Rezoning Transportation Analysis

Petition Number: 2023-024

Date	Description
06-28-23	First Review (TM)

SHEET NUMBER
RZ-2

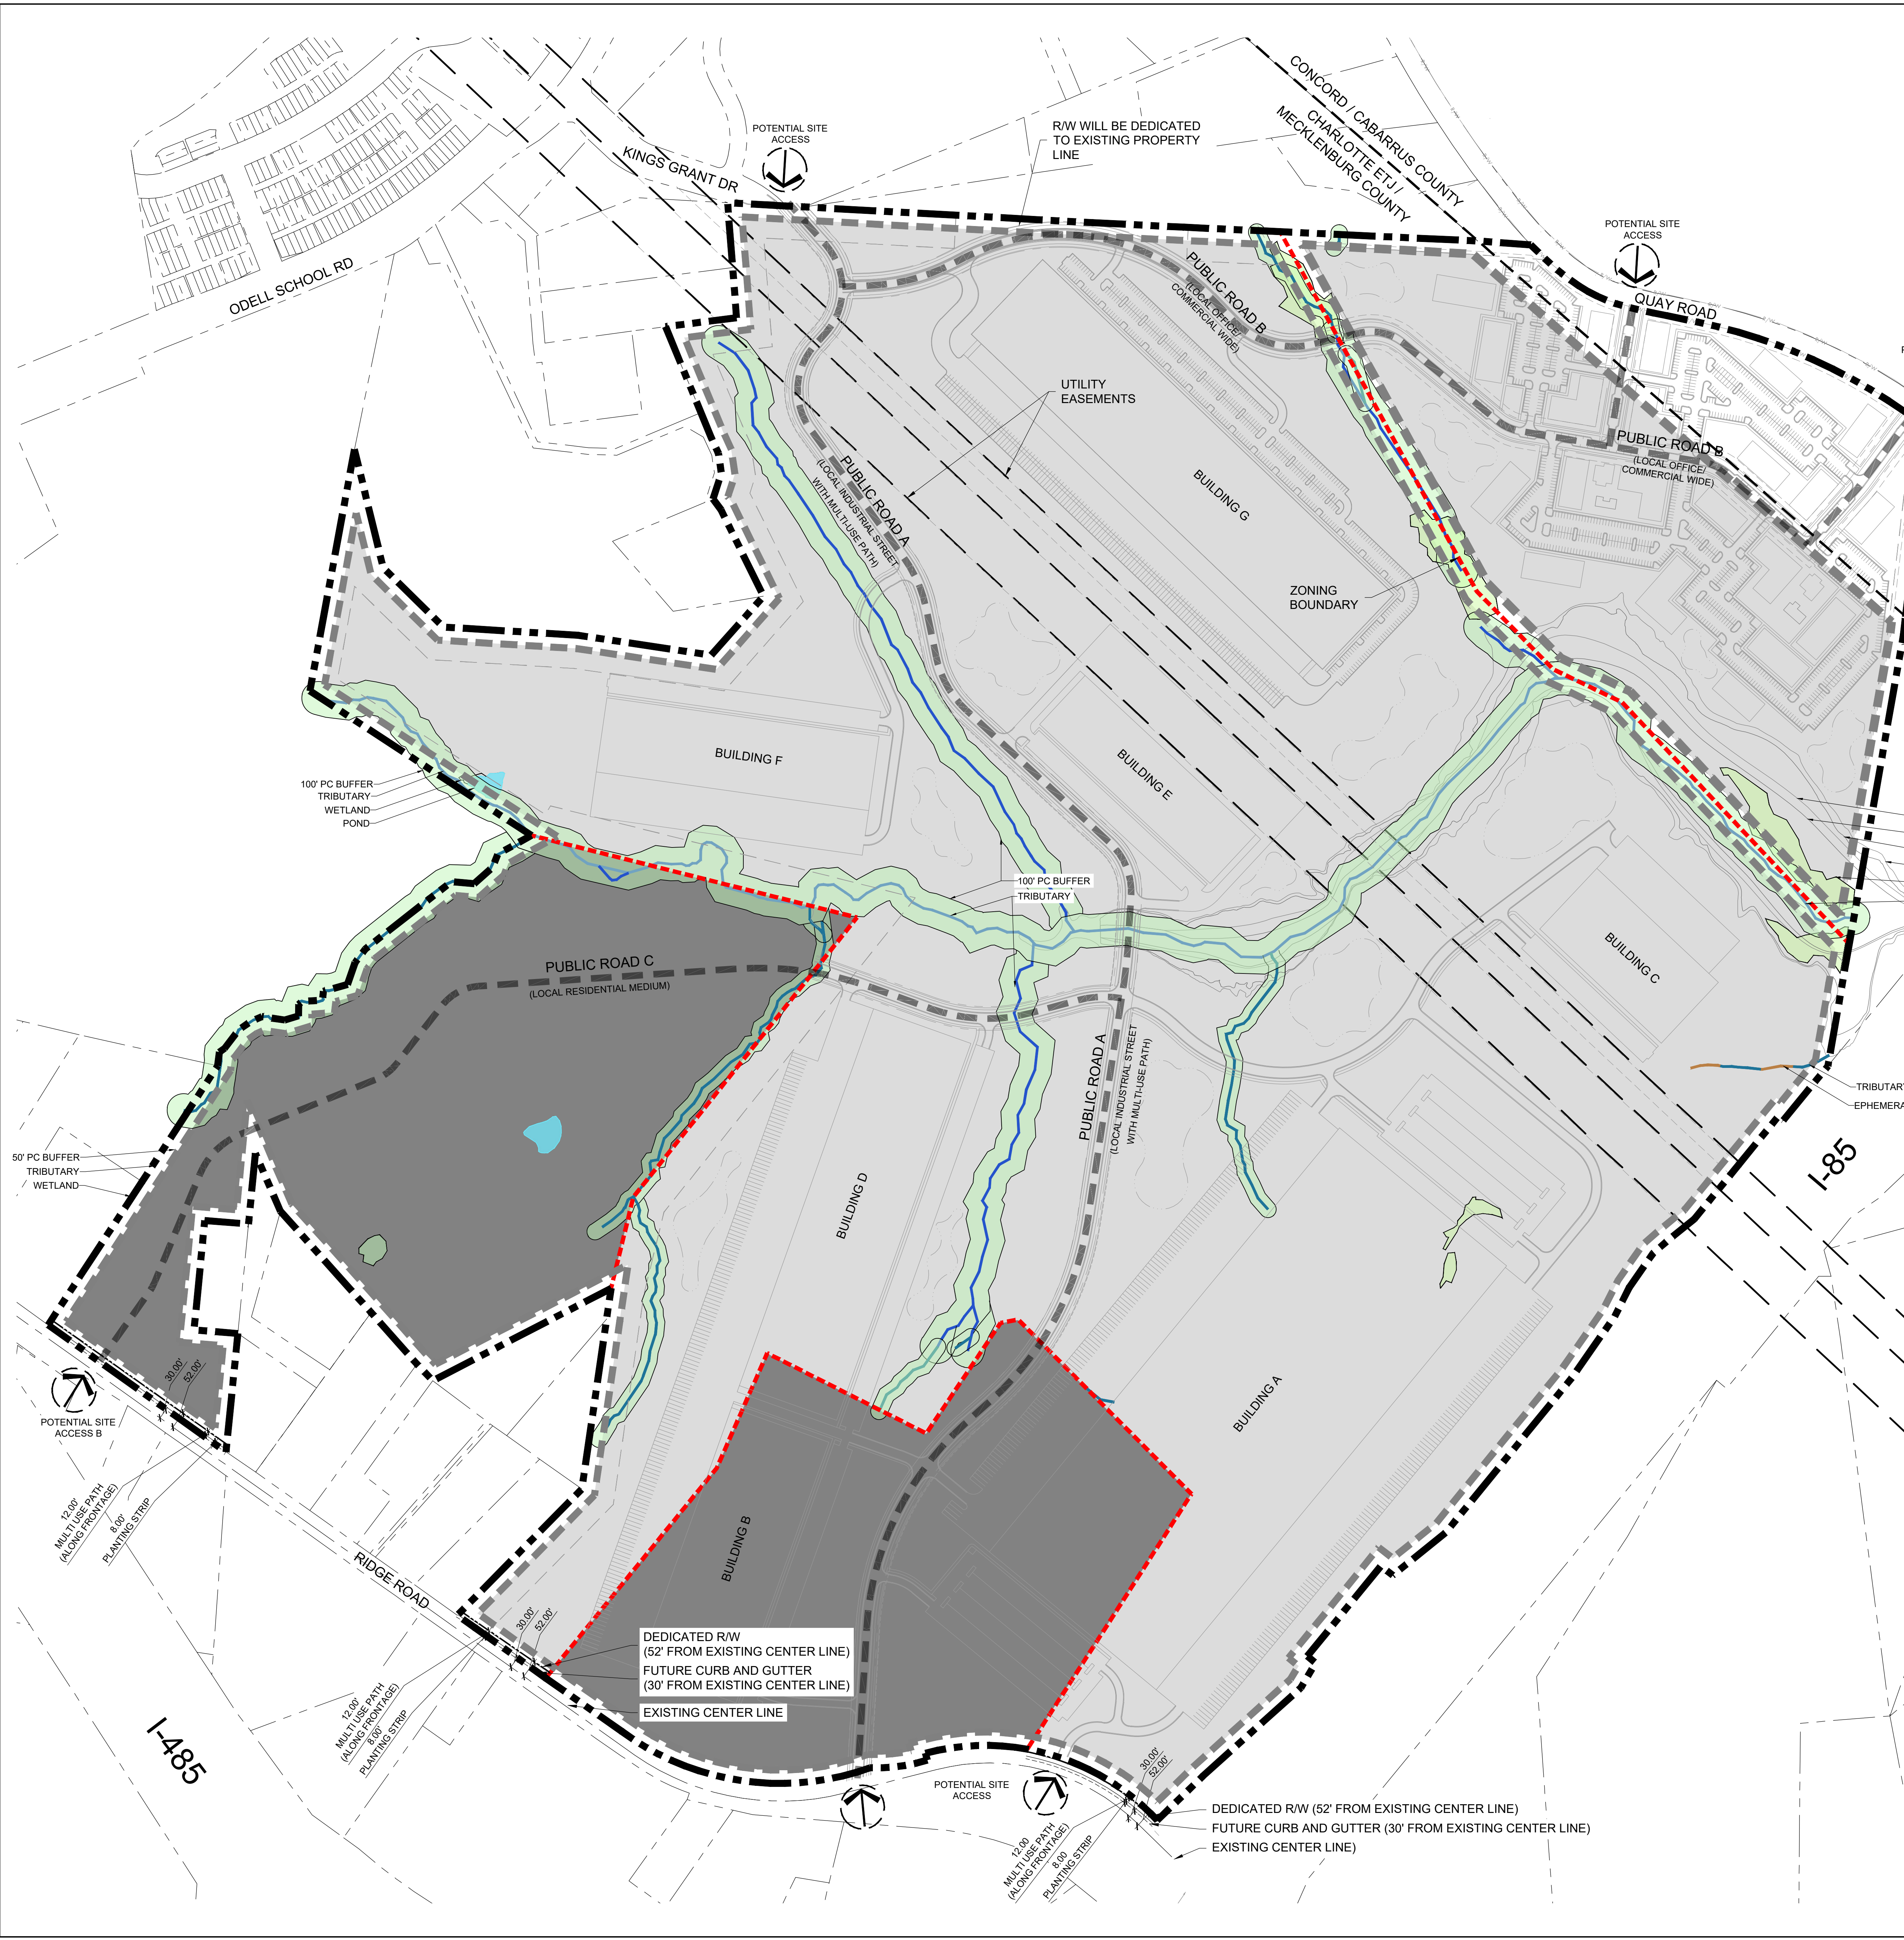
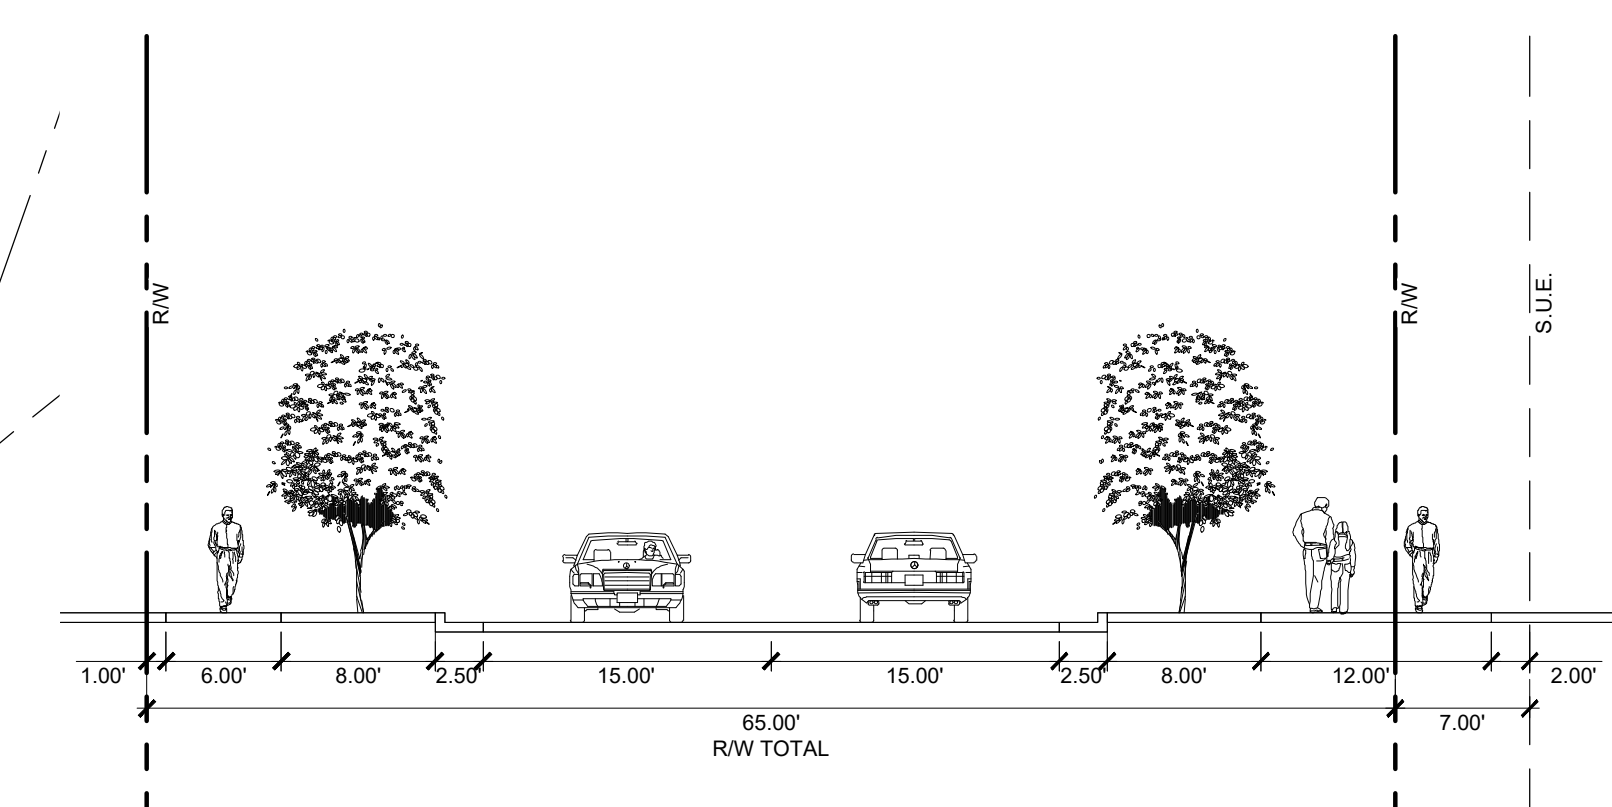
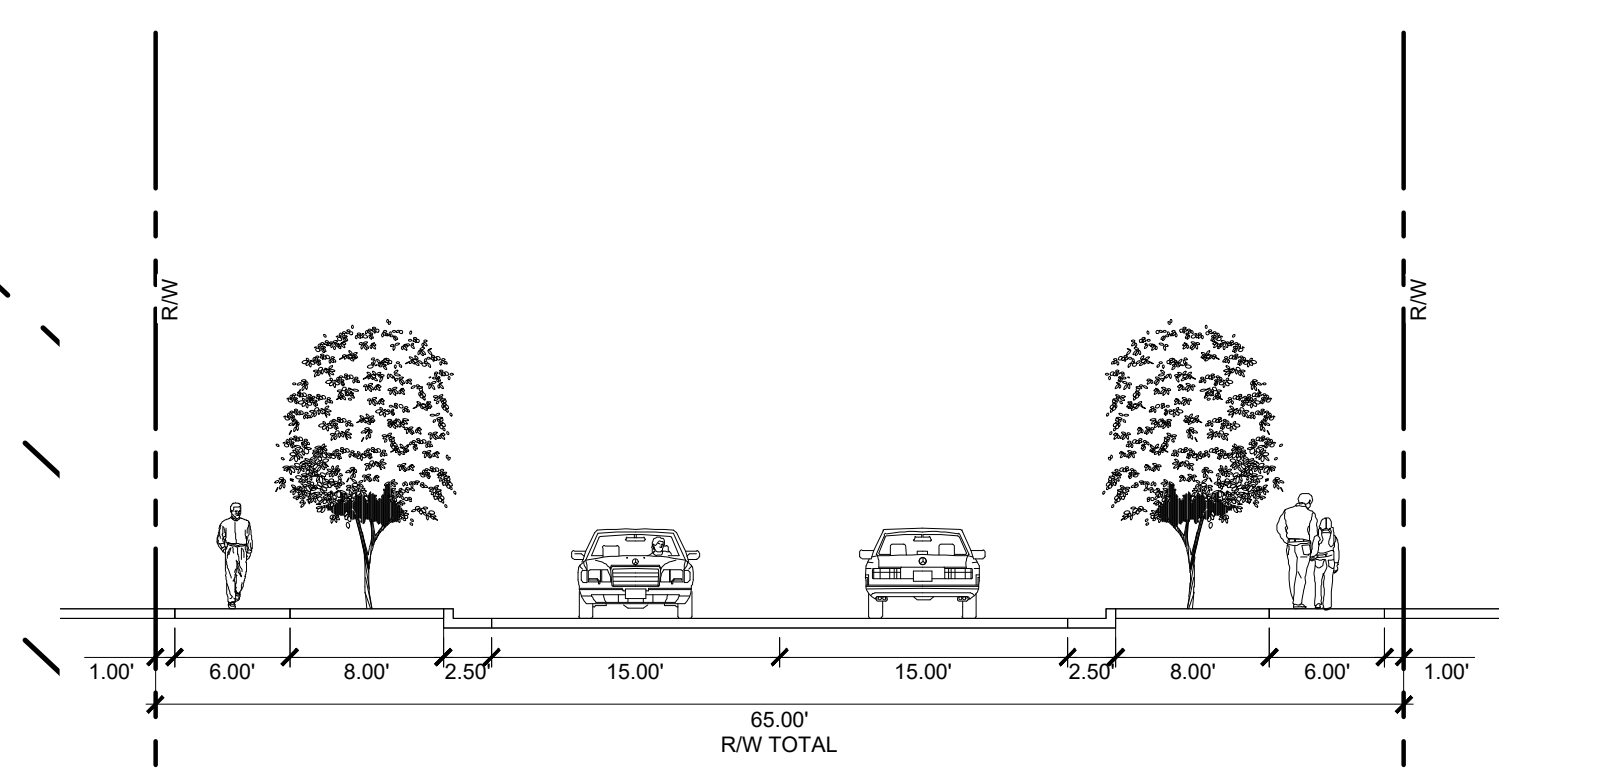
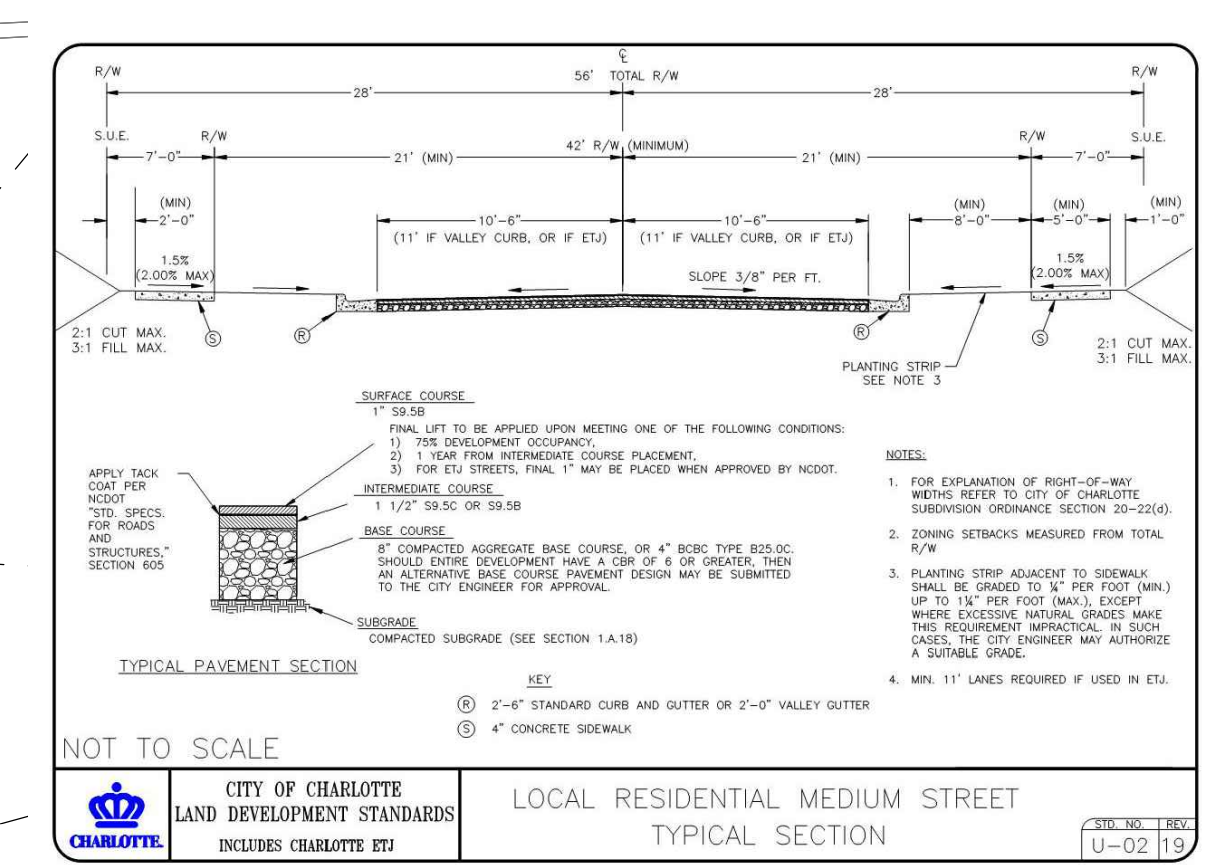
3. Revise site plan and conditional note(s) to commit to coordinating internal street network with rezoning 2023-018. Site plan shall show connection locations between rezonings.
